City of Albuquerque Stormwater Construction Site Inspection Report

General Information					
ESC File No.	G19E004I	Project Name:	Tract 6 & 8 Wymont Subdivision		
NPDES Id. No.	NMR1006VN	Location:	8201 La Morada		
12/5/2024	Owner	Contractor			
Operator	Mira Al Sol, LLC				
Contact name & title	Ben Perich				
e-mail	ben.perich@colliers.com				
Contact Phone #	505-507-1678				
COA Inspector	James Hughes	Time	8:30am		
Construction Phase:	grading				
Type of Inspection:	Regular	Storm Event	Post Storm Event >0.25"	311/Complaint	Follow Up
Weather at time of inspection?			Temperature: ~	50	
Estimated date of last storm 0.25" or greater	11/7/2024

ESC-1

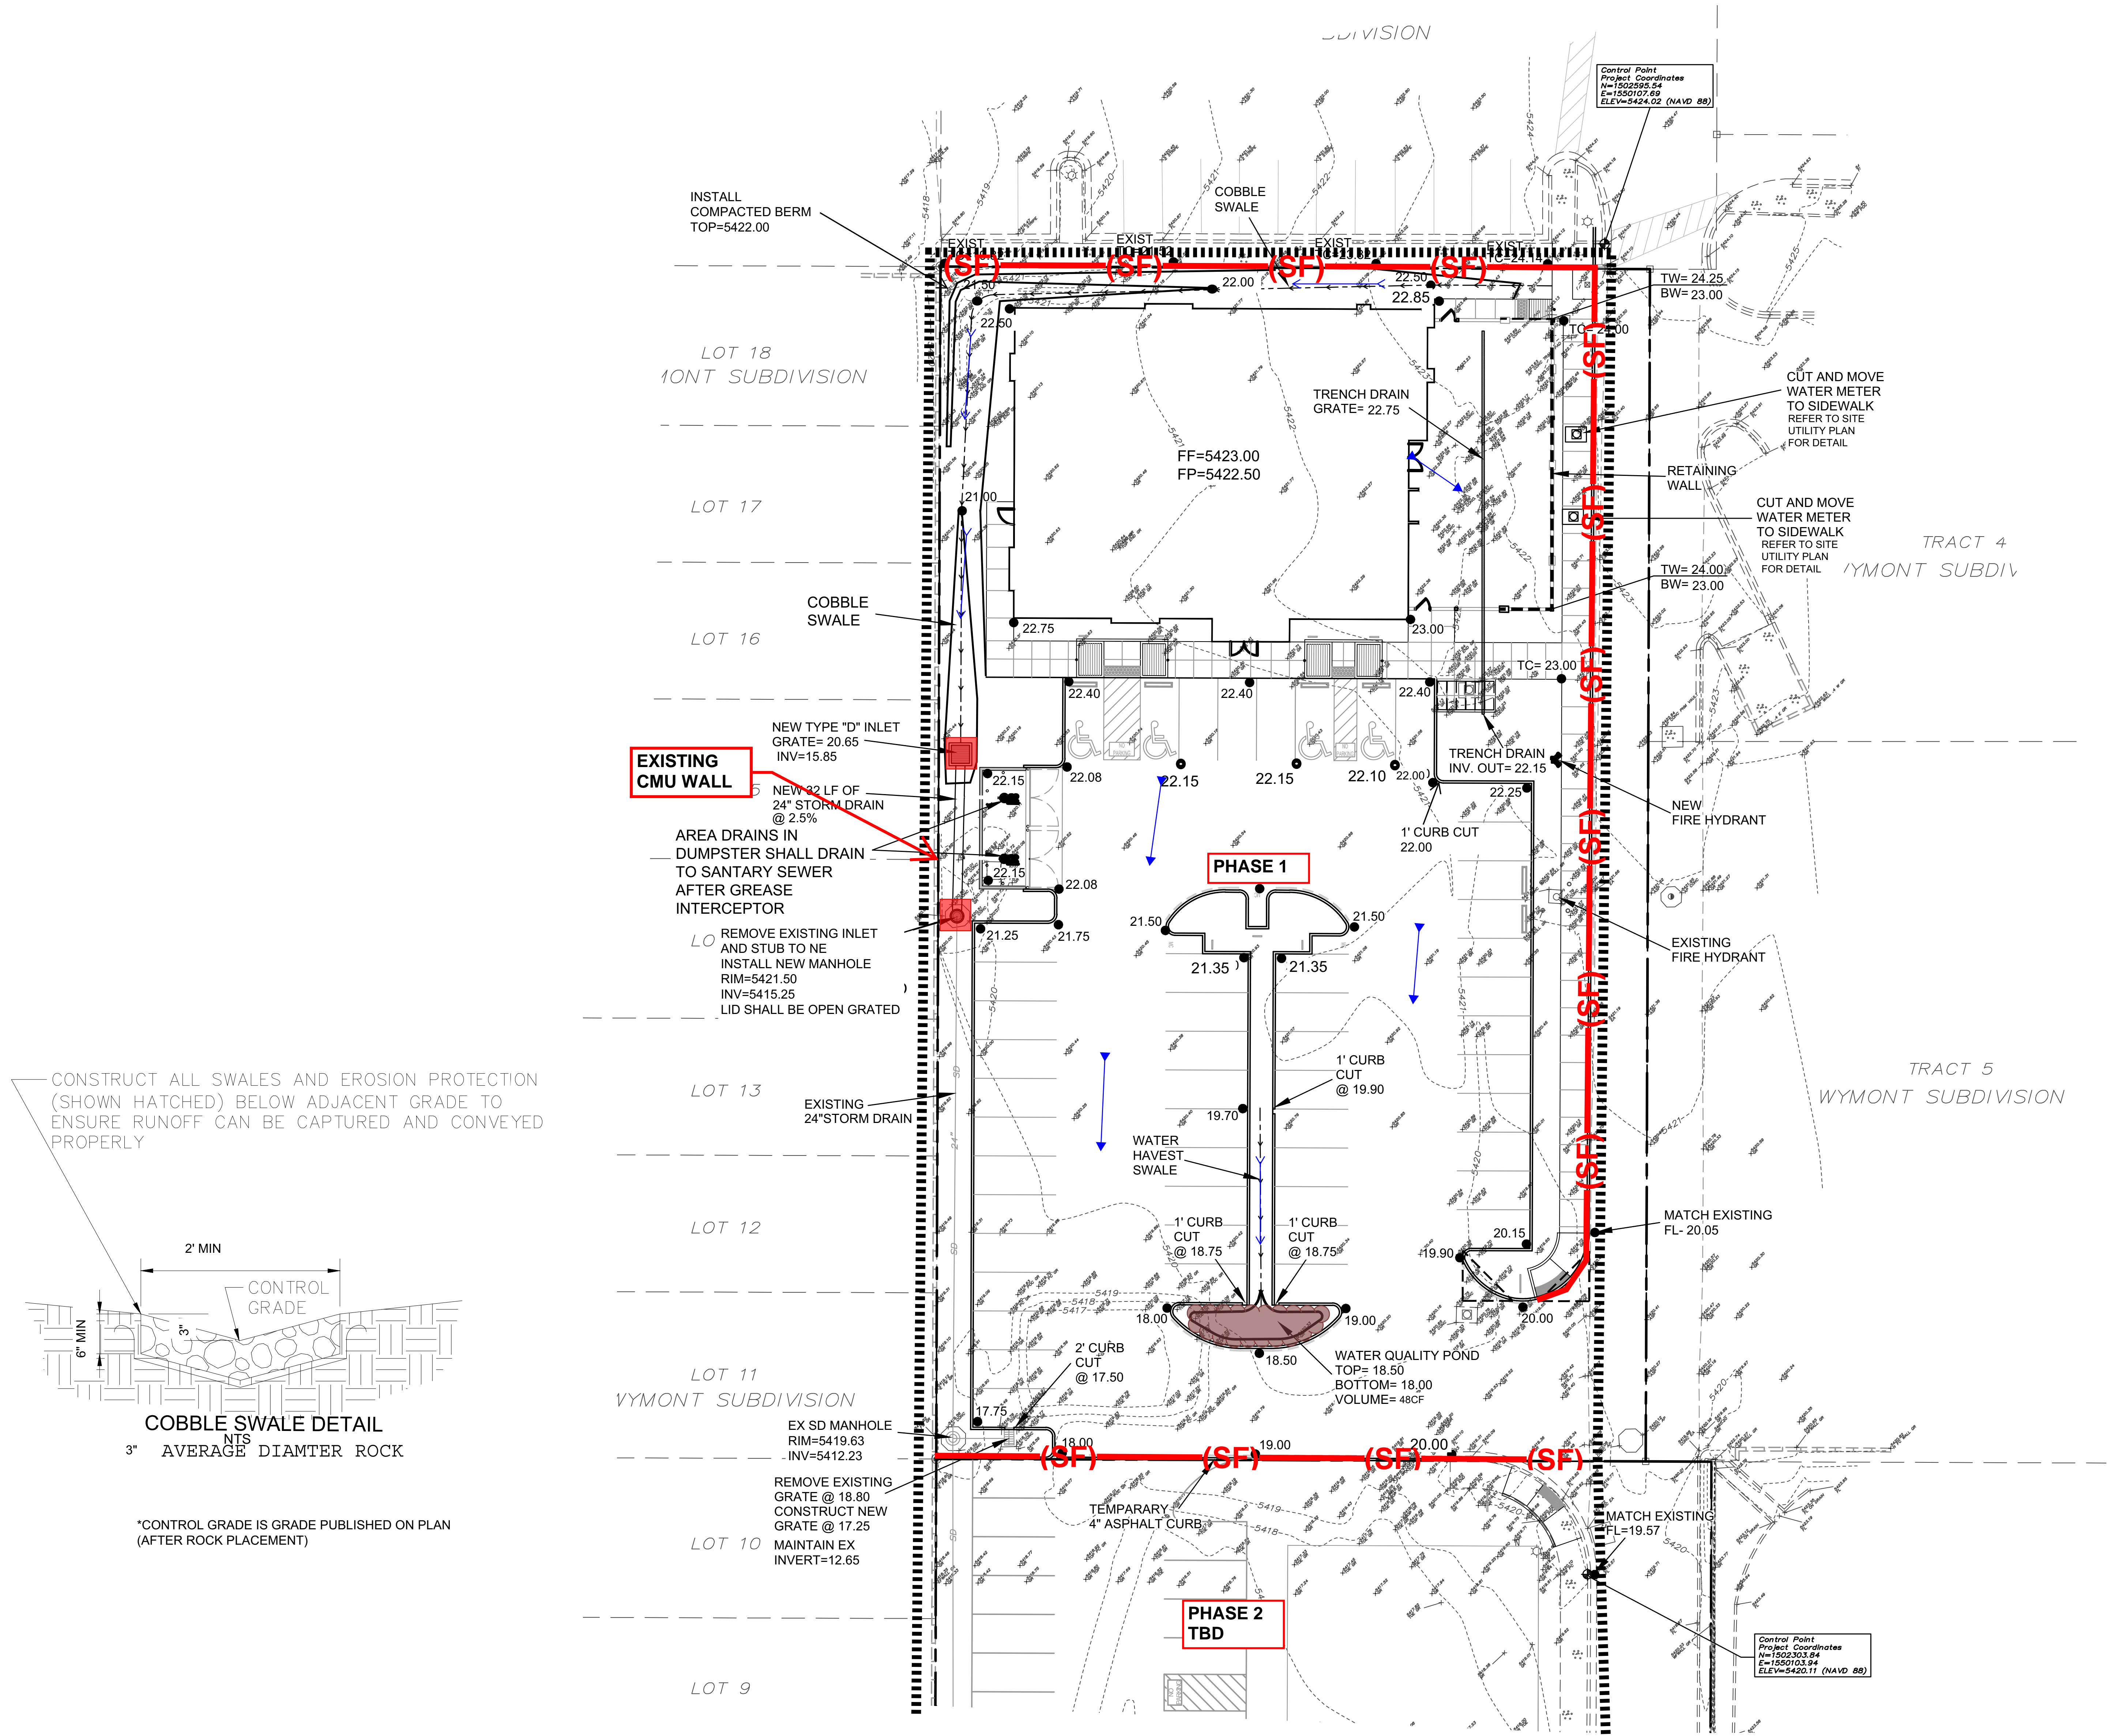
3	<p>BMPs - the new silt fence was cut/broken in the southwest corner of the site (See the attached Photo). Required mitigation: If at any time you find that a stormwater control needs routine Maintenance, you must immediately initiate the needed maintenance work and complete such work by the close of the next business day. When the problem requires a new or replacement control or significant repair, install the new or modified control and make it operational or complete the repair by no later than seven (7) calendar days from the time of discovery per CGP 5.2.1.</p>				
4
